Subject: FW: Planning Consultation on: AW/120/12/

APPLICATION AW/120/12/

Site Address: Barclays Bank Plc 6 Nyetimber Lane Bognor Regis PO21 3HG

Description of Works: Installation of 1 no. new condenser unit

12M ZONE IN RELATION TO NEIGHBOURING PROPERTIES.

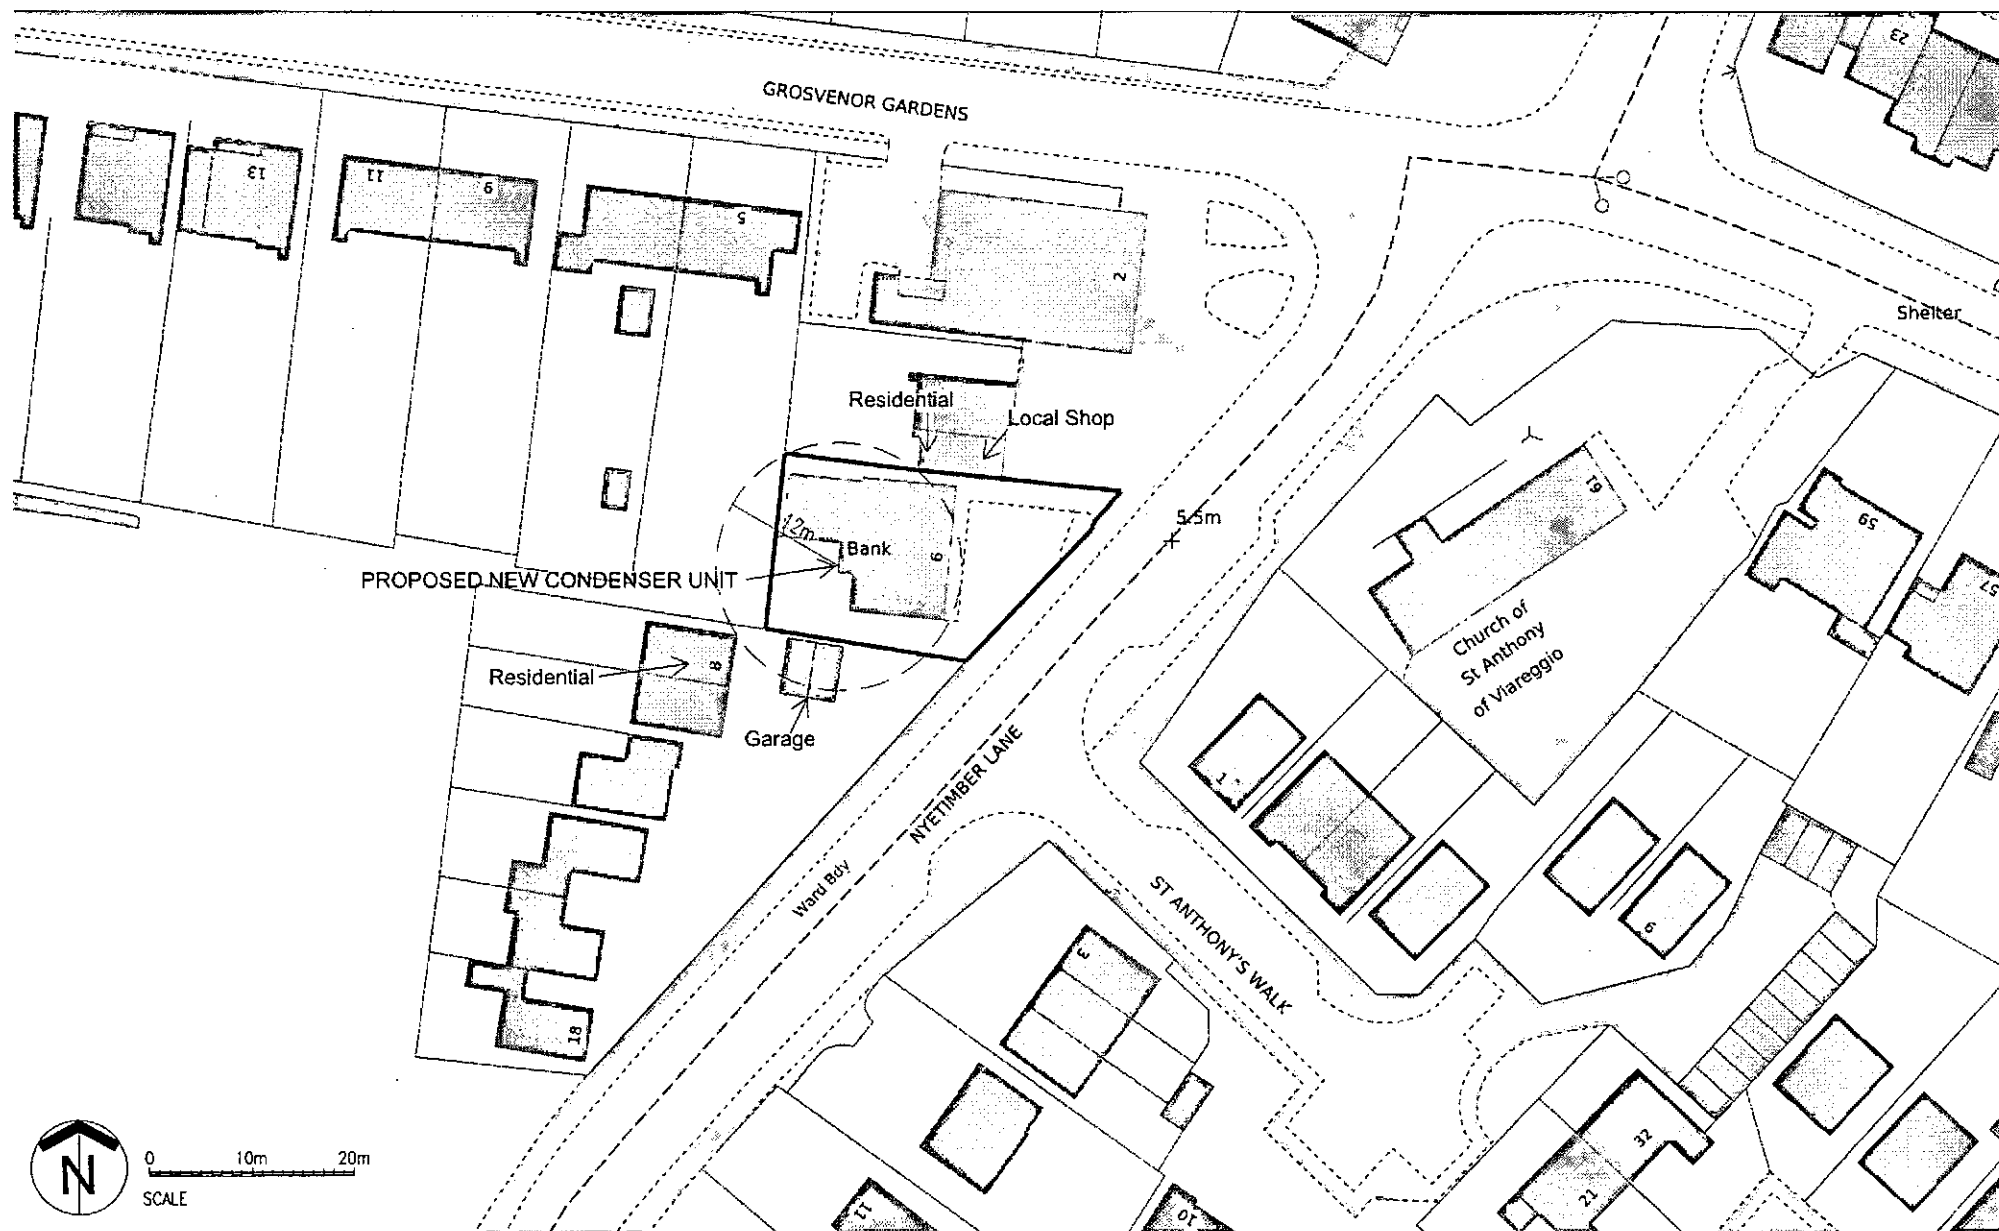
It is unclear from the information submitted which specific external unit is proposed. The Ground Floor Mechanical Services Layout Plan suggests that the proposed condenser produces 48dBA, it is not clear whether this represents a sound pressure or a sound power level. Ideally a sound pressure level at a given distance from the unit should be provided.
 No information is provided on existing (background) noise levels (it is noted that there does not appear to be existing plant or other noise making plant in the vicinity), or on proposed hours of operation of the condenser (noise produced is less likely to be significant if use is restricted to bank opening hours). Please also clarify whether there is residential accommodation above the application site (submitted plans indicate not), otherwise the nearest noise sensitive premises appears to be approximately 12m from the condenser unit?
